**NSIP Reference: EN010158**

**Natural England's Written Representations in respect of Rosefield Solar Farm**

**Examining authority's submission deadline: 10<sup>th</sup> March 2026**

## **Landscape and Ecological Mitigation and Enhancements**

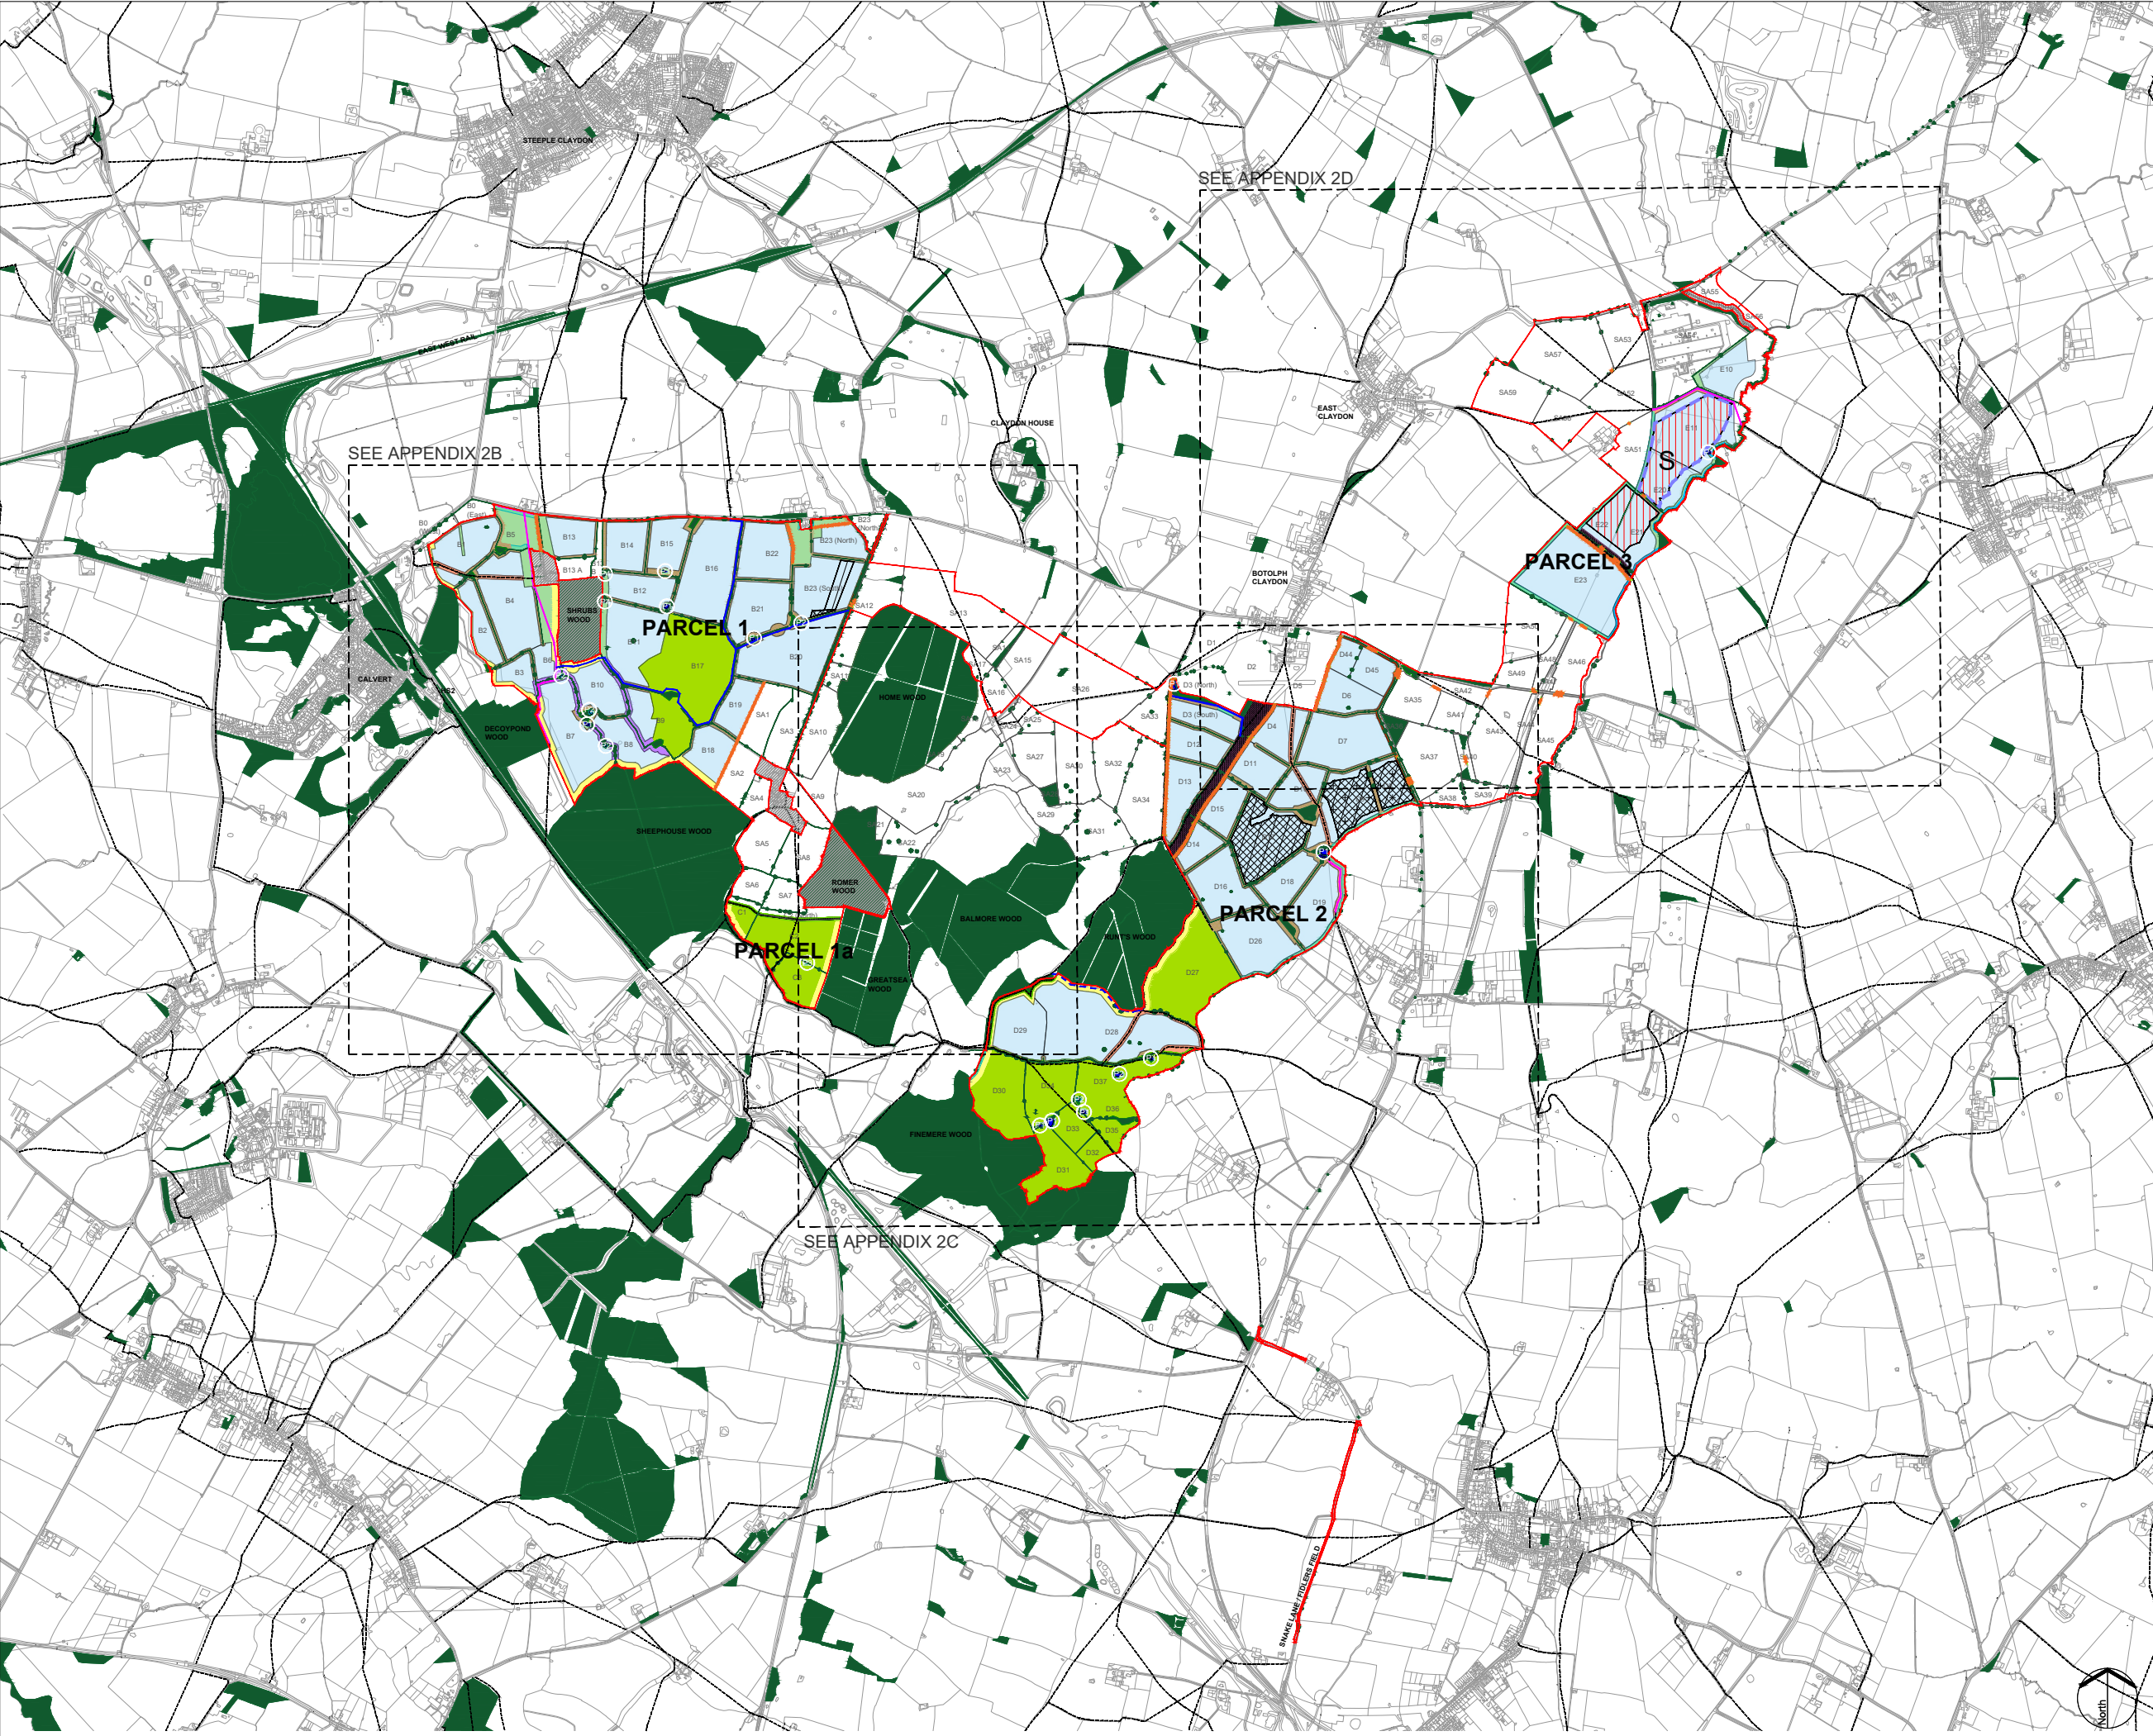
We thank the Applicant for confirming that the 93ha of mitigation habitat will be cattle grazed. It would be reassuring if the Outline LEMP reflected a commitment to this, as opposed to only 'potential for grazing by sheep or cattle' (as per the plans in Appendix 2 Landscape and Ecological Mitigation and Enhancements) and 'cattle may be used to graze the larger grassland areas' (para. 5.2.4).

We note that the LEMP states further detail on the timings and stocking densities of the grazing will be provided at the detailed design stage. The current version of the LEMP highlights the benefits of conservation grazing and the mapping includes areas 'with potential for grazing by sheep or cattle'.

Appendix 4 includes 'grazing options' for 'Neutral Grassland', and 'Species-Rich Grassland/Wildflower Grassland/Wetter Grassland' (which encompass the retained and created grassland fields) and the option is to use sheep or cattle at a low stocking density and moving stock regularly. Currently the management prescription for all grasslands, including the herbal leys beneath PV panels as well as the above listed grassland types, excludes any grazing in the summer months to allow plants to flower and set seed. However, for continuity in prey abundance for bats it would be beneficial to ensure that there is some grazing throughout the spring and summer as well, which could also be across rotationally managed areas so as to provide the varied sward that the LEMP is seeking to achieve, whilst avoiding a period when bats are breeding and livestock are not present.

Removal of Solar in B6, B7 & B8

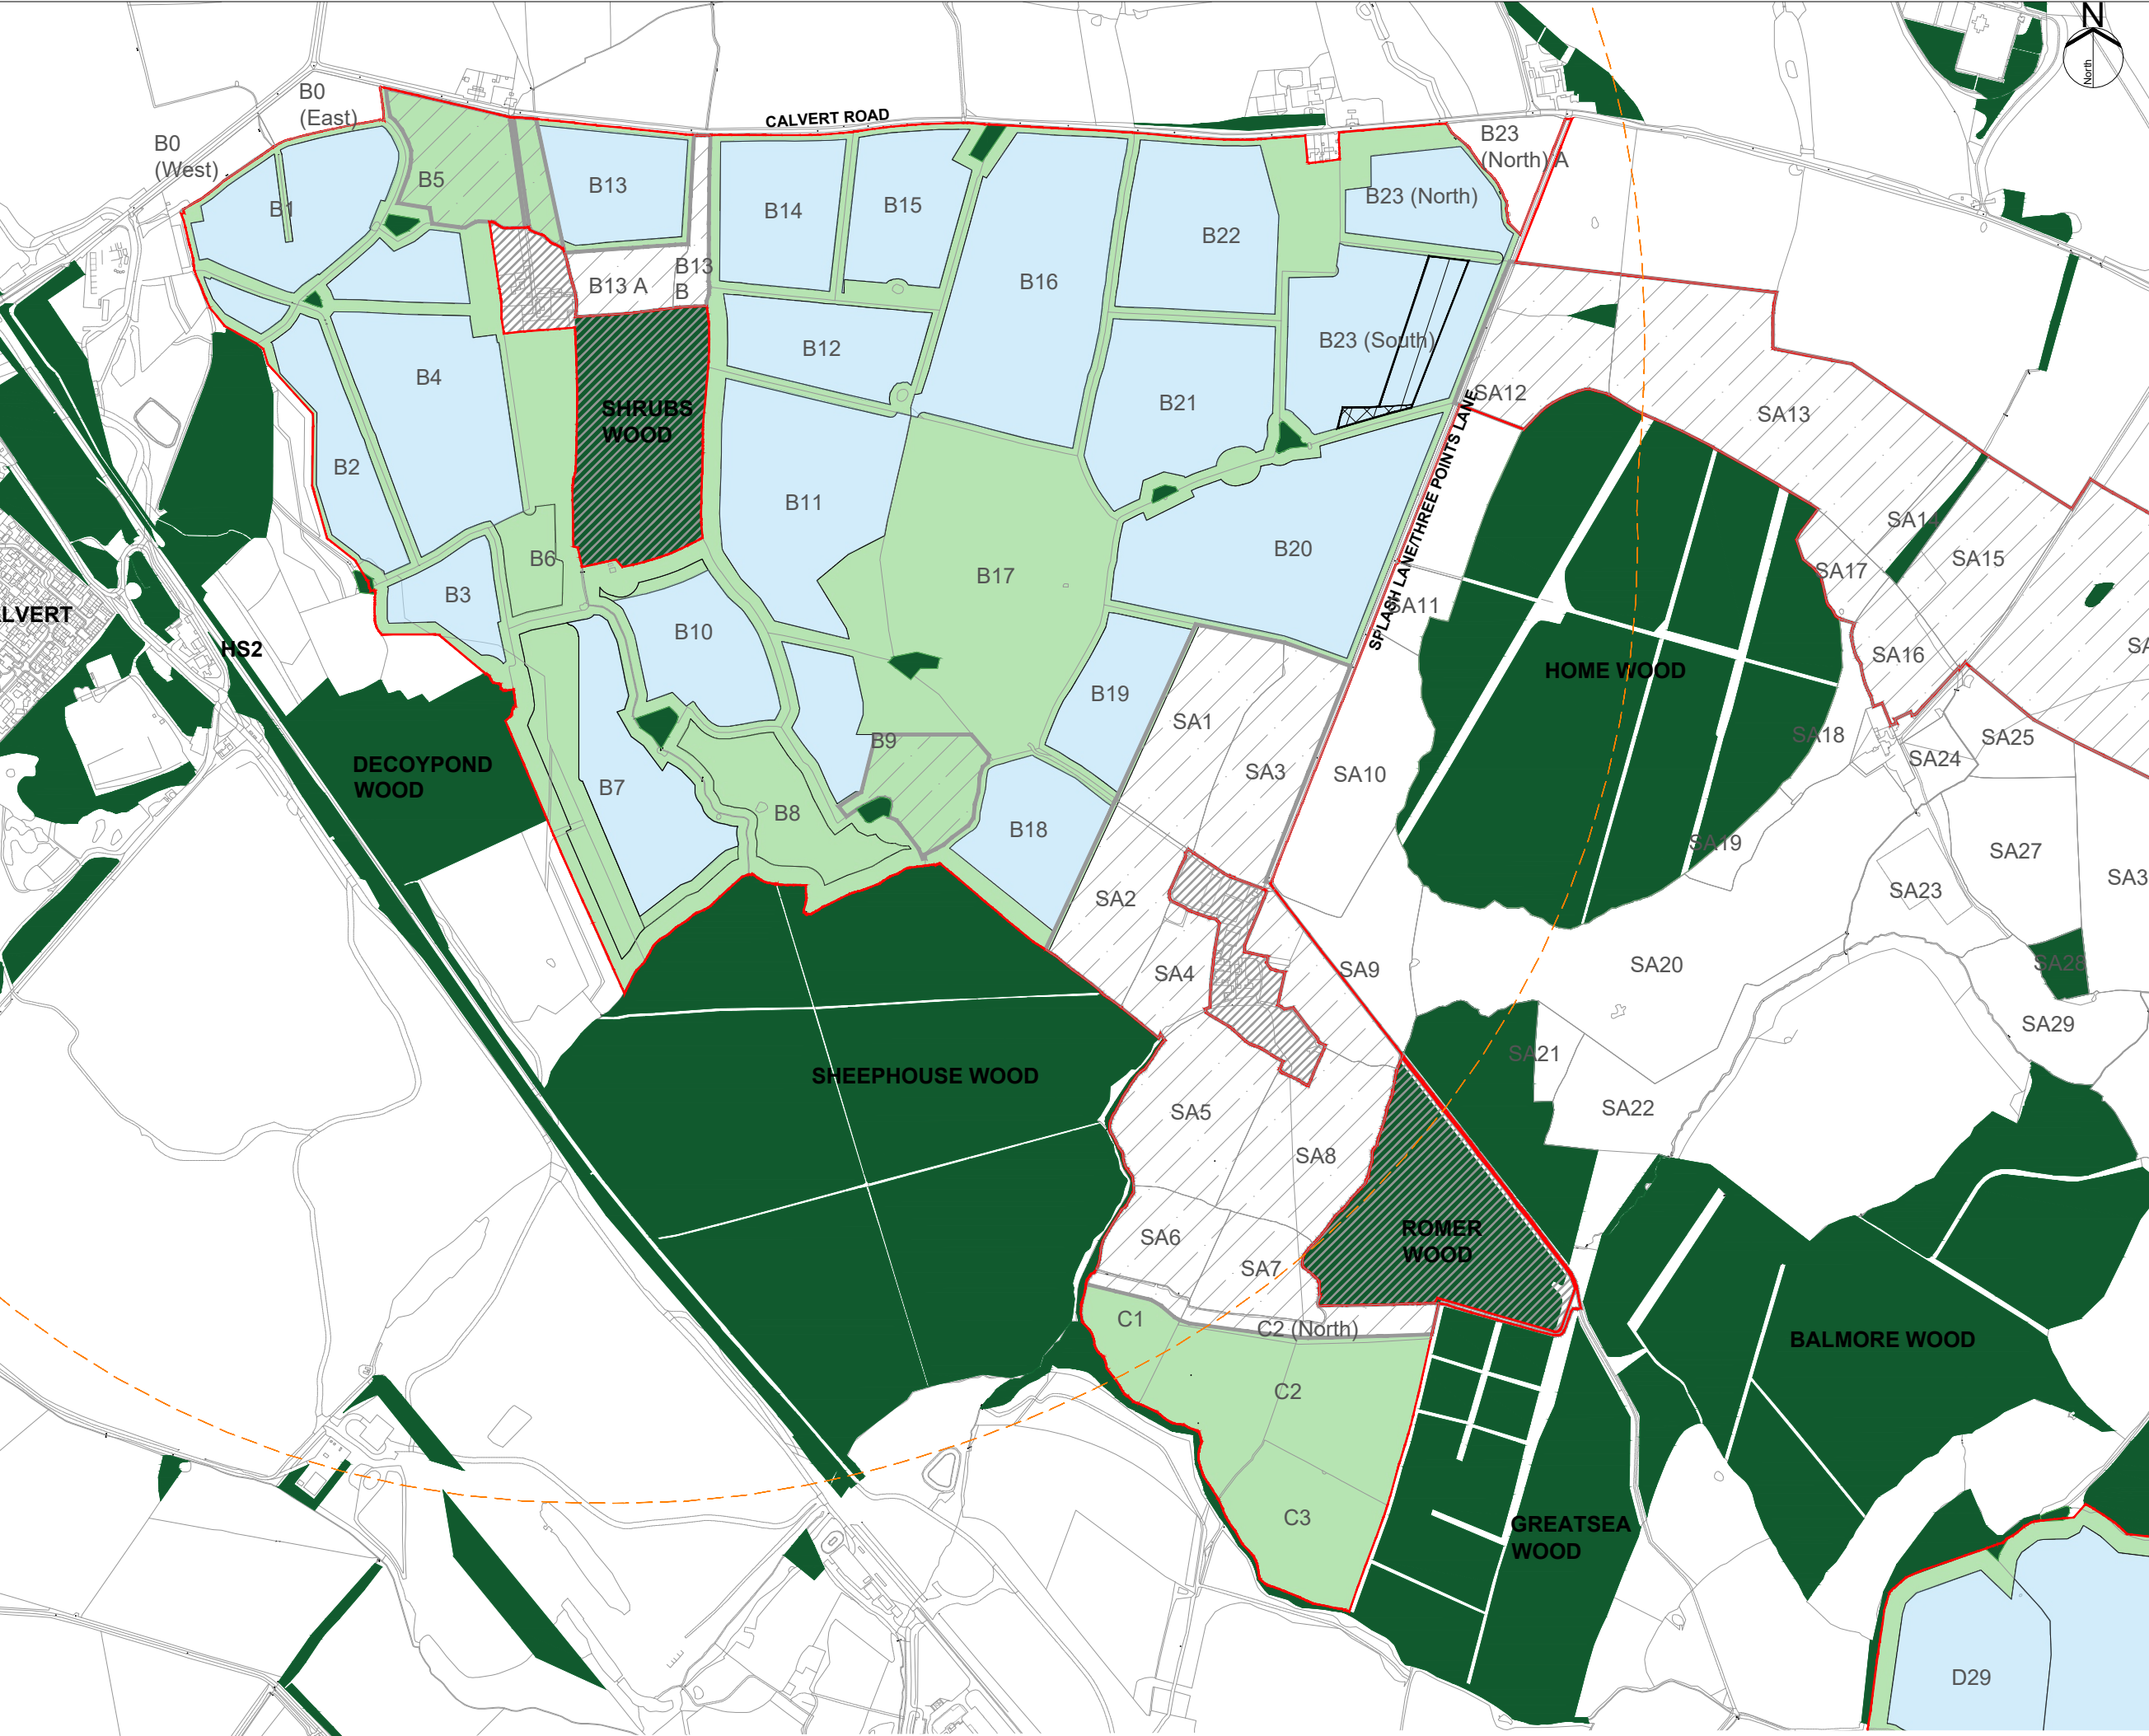
Natural England has consistently raised concerns about the loss of grassland field parcels close to Shrubs Wood, north of Sheephouse Wood. NECR558 describes the value of this area, which the Applicant has both recognised [PDA-006 page 212] but also downplayed, describing the area as 'intensively managed and species-poor', and grazed by 'a non-organic cattle herd'. We have provided extensive commentary in our relevant representations on why there is insufficient evidence provided to discount the value of this area. Current best available evidence shows that this is a valuable area, even with the current agricultural practice and we advise that a precautionary approach must be taken.

The Applicant has responded to our request to clarify the total areas of retained and enhanced grassland habitats and explained that there is roughly a 2x re-provision ratio for lost grassland habitat. As in our relevant representations [RR-203], we welcome the mitigation and habitat provision across the rest of the site. It should be noted that the bulk of the re-provided habitats are up to 3km away from Shrub's Wood. While it will likely function for the affected population, the loss of fields B6, B7 and B8 represent a significant change from the current conditions. We continue to advise that in order to ensure continuity of the existing habitat and distribution of foraging resources, that panels are removed from these fields.

The Applicant makes a distinction between buffers being provided for connectivity and grassland being provided for habitat, so 'establishing 15m buffers between Sheephouse Wood and Shrubs Wood is adequate to ensure connectivity'. While acceptable at face value, this is not a very nuanced approach. This part of the landscape offers a different resource from habitat elsewhere, it is largely low lying and therefore sheltered by Sheephouse Wood, which will influence invertebrate movements and congregation. When looking at a landscape scale, there is grassland retained or created in the south and south-east of the development, but nothing else to the west or the north except field B17 which is much more exposed and is retained primarily for landscape, rather than ecological reasons. Whilst the two are compatible, this would not otherwise be a key area to set aside for mitigation for bats as it does not provide the linkages or sheltered foraging of B6, B7 and B8.

Another reason for retaining grasslands B6, B7 and B8 and utilising them for cattle grazing and habitat enhancements is the critical location in an area heavily affected by construction and operation of HS2. Leaving these fields undeveloped will complement the mitigation measures for HS2, maintaining and strengthening linkages between Sheephouse Wood, Decoy Pond Wood and Shrubs Wood to build resilience into the landscape for Bechstain's bats into the future. At present there are no known maternity roosts within Shrubs Wood or Decoypond Wood, only day roosts within the latter, but by maintaining and strengthening habitat linkages the future value of these woodlands is enhanced rather than diminished.

Removal of panels from B6, B7 and B8 would therefore not only avoid impacts of loss of this area, but, with appropriate management, would also provide a suitable grazed, sheltered and connected location where habitat enhancement measures could be used to mitigate/compensate for impacts elsewhere. Given the National importance of the population, the unknown efficacy of the mitigation measures proposed and the existing pressures on this population from development, our recommendation is still that development is reduced in this area.
